Howerton Services, PLLC
License # P-1716
3513 Cathedral Bell Road
Raleigh, NC 27614
(919) 270-3460

Subject: Lot 1
3180 Oakridge River Road
Fuquay Varina, NC 27526
Plan Revision Letter
Harnett County Permit #: SFD2505-0171

Based on the request of the Contractor, 1 item on the plans will be revised. My assessment and recommendations are as follows:

S1 FOUNDATION
1/4"=1'-0"

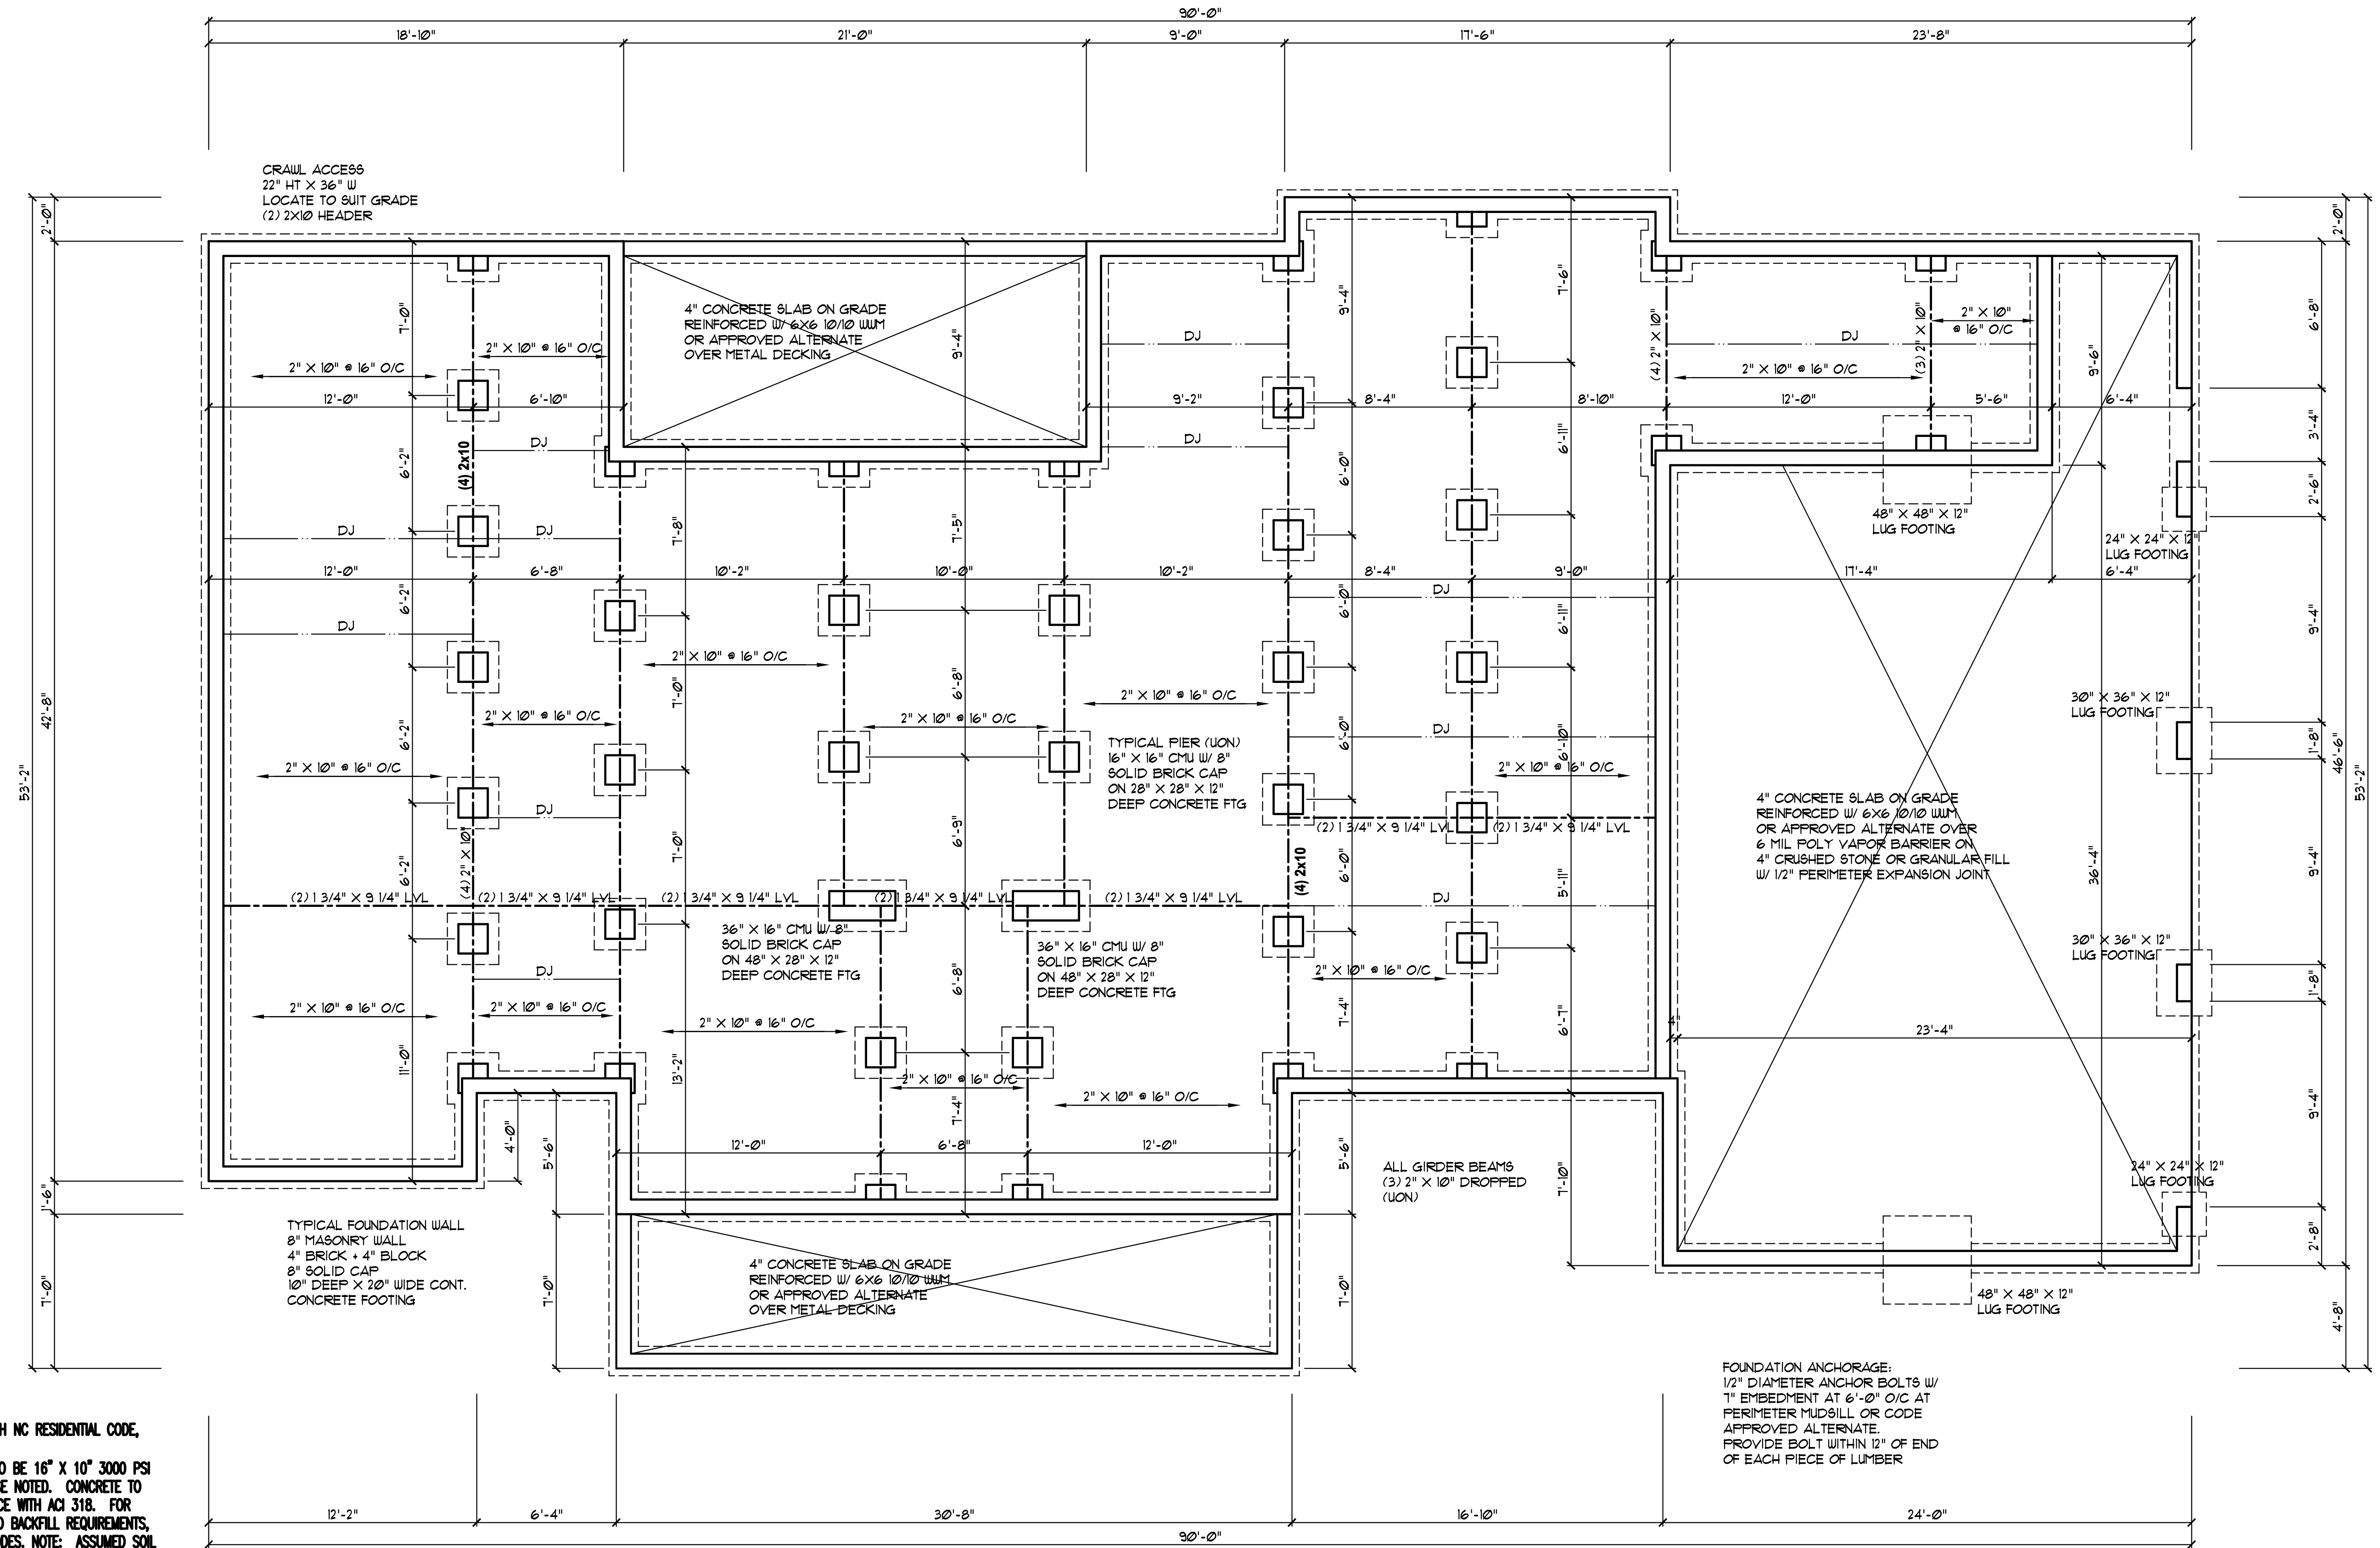
- The 2 - #4 bars shown on the plans for the continuous footings will not be installed. Removing the rebar from the footings is acceptable.

The footings without the rebar meet all the requirements of the 2018 North Carolina Building Code for Residences.
